**WEST SUSSEX COUNTY COUNCIL
STRATEGIC PLANNING CONSULTATION**

**SUBJECT: R-131-17
Land Adjacent Abbots Lodge
85 The Street, Rustington
West Sussex, BN16 3NL**

6No. one bed apartments - This application affects the character and appearance of the Rustington Conservation Area.

SITE PLAN SCALE 1:200 @ A3

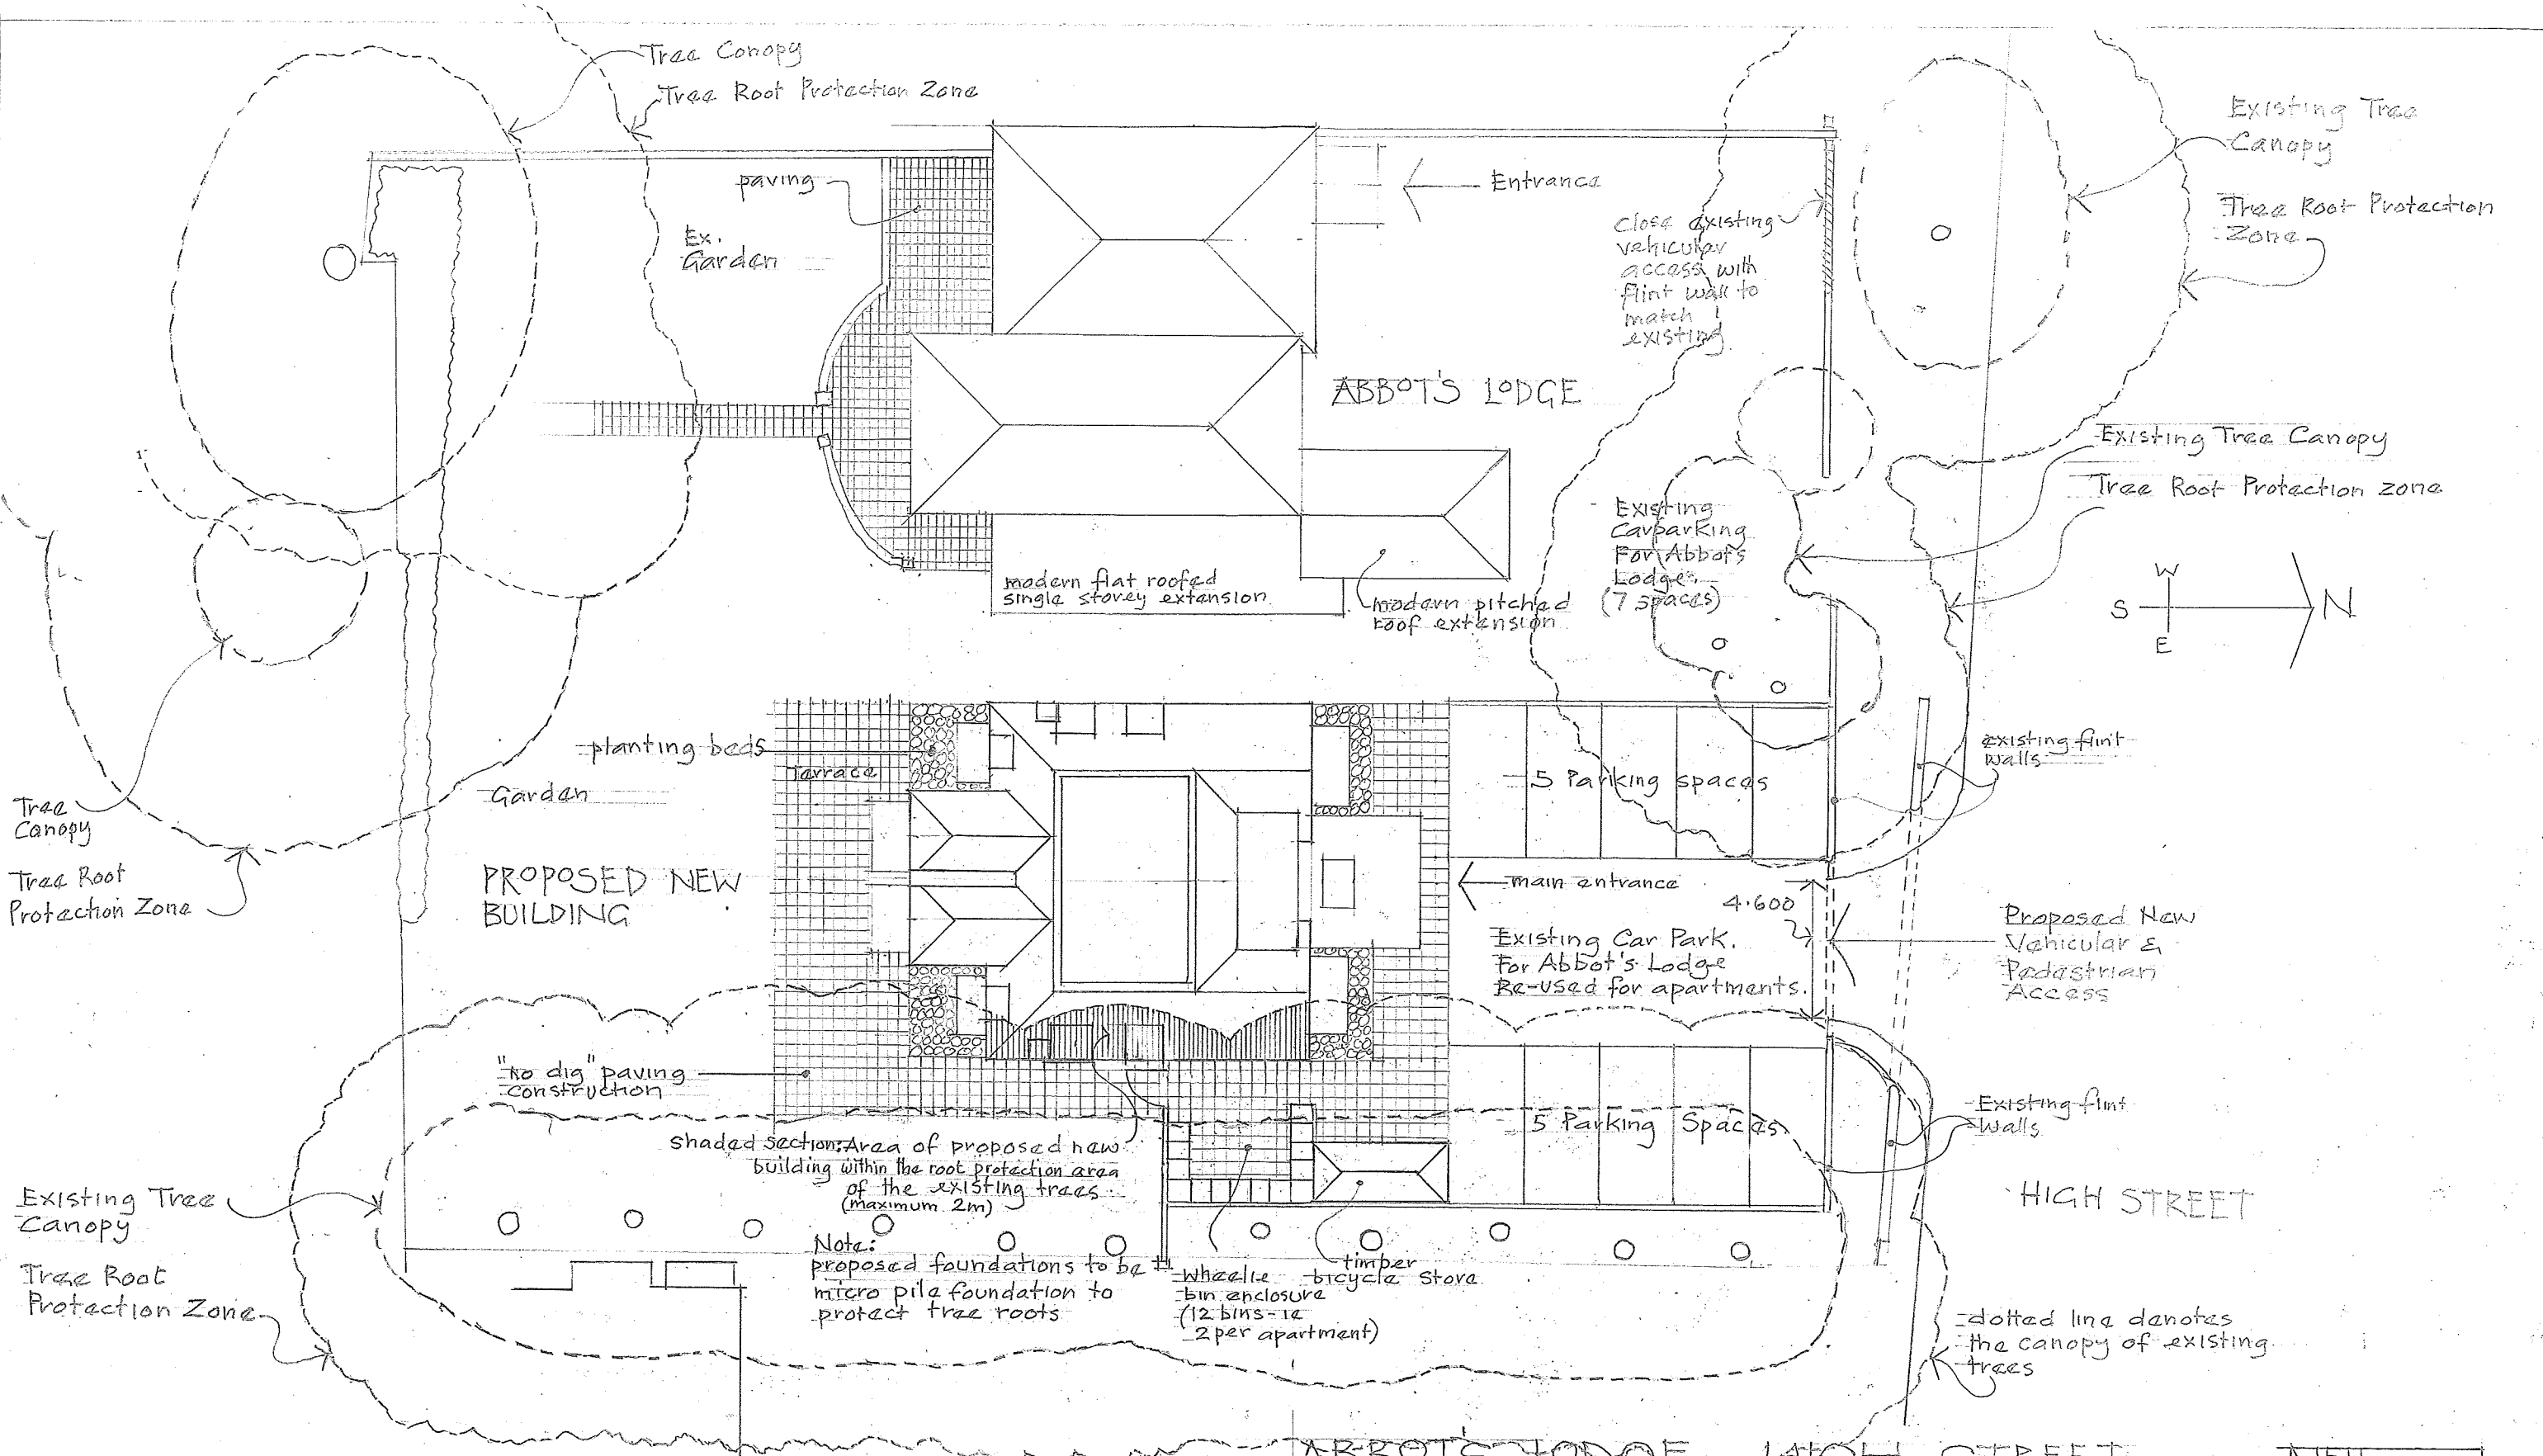
No objection is raised 'in principle' to the proposal above however; more information should be submitted regarding the new access onto The Street. Current plans show a 4.6m wide access would allow two cars to enter and exit simultaneously. Visibility splays should be provided using Manual for Streets guidance for 30mph roads. These are typically 2.4m set back from the carriageway edge with a 43m visibility splay in each direction. The Street is a straight road and although trees or street furniture might partially obscure visibility this should be achievable. Once the visibility splays are submitted to the LPA this can be confirmed.

The layout of the highway here is also slightly unusual. There is a low wall separating the edge of the kerb and footway with a concrete and flint mix infill creating a hard verge. This may be part of a historic traffic management scheme to prevent parking on the highway here. This would not cause any construction issues at the new access but a section 278 agreement would need to be progressed to ensure the access is constructed in line with WSCC guidance.

The applicant also proposes to close the access to the far west of the site. Details of this closure would need to be provided as part of the S278 for the site and be shown on the plans how this will look. Guidance can be found on our website, in our information for developers section.

WSCC car parking standards suggest a maximum of 10 car parking spaces would be required for a development of this size. 10 spaces are provided in a courtyard arrangement to the front of the property. Each space should be at least 2.4m x 4.8m and 1 space provided for disabled users.

Cycle parking which is covered and secure will be included in the development and satisfies current guidance in the NPPF for sustainable development.

No part of the development shall be first occupied until visibility splays of 2.4 metres by 43 metres have been provided at the proposed site vehicular access onto The Street in accordance with plans and details submitted to and approved in writing by the Local Planning Authority. Once provided the splays shall thereafter be maintained and kept free of all obstructions over a height of 0.6 metre above adjoining carriageway level or as otherwise agreed.
